From: Michael Eastham
Sent: 28 February 2019 13:28
To: Planning.Responses
Subject: FW: Planning Application A/26/19/PL - Quiet Waters - Angmering

From: Robin [REDACTED]
Sent: 28 February 2019 12:58
To: Michael Eastham
Subject: Planning Application A/26/19/PL - Quiet Waters - Angmering

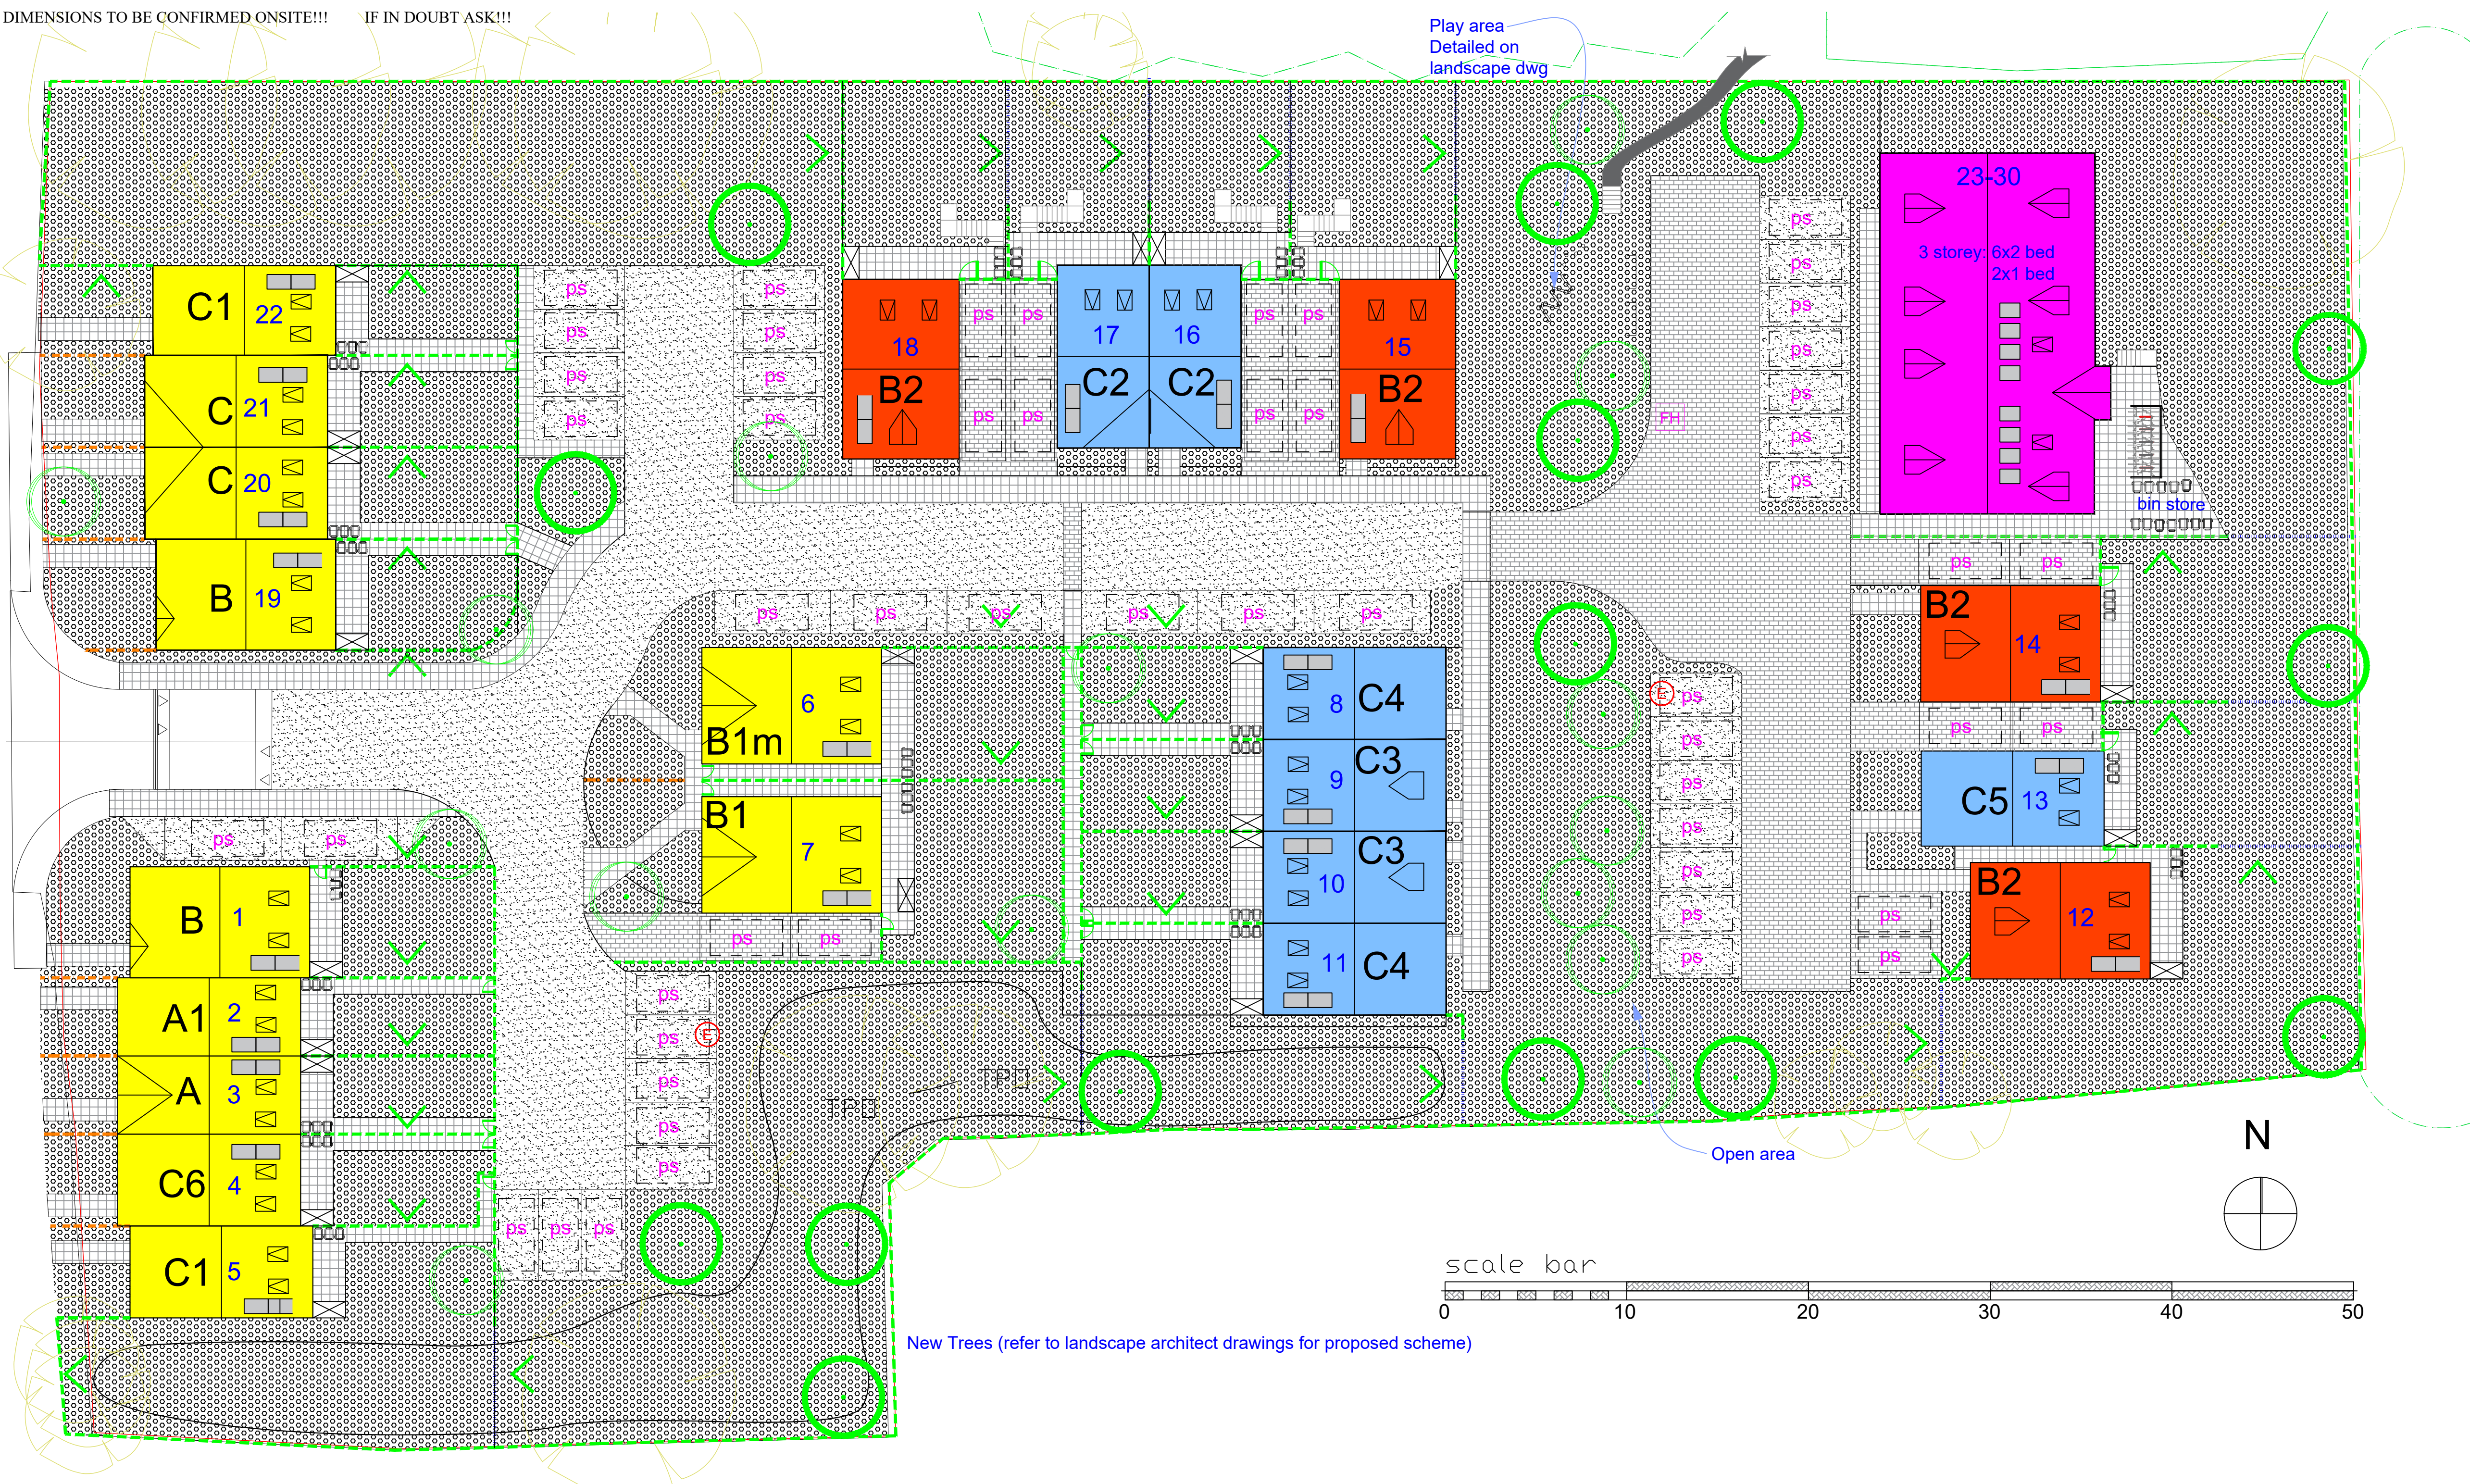
The applicants justification for this change states there is insufficient electrical load capacity to accommodate the 20 charging points but sufficient for 2 charging points.

It seems, therefore that neither Arun nor the applicant investigated whether or not the existing electrical load capacity could accommodate these 20 EVCPs on this site prior to planning approval. If the developer had then perhaps they would not have submitted their application to include EVCPs.
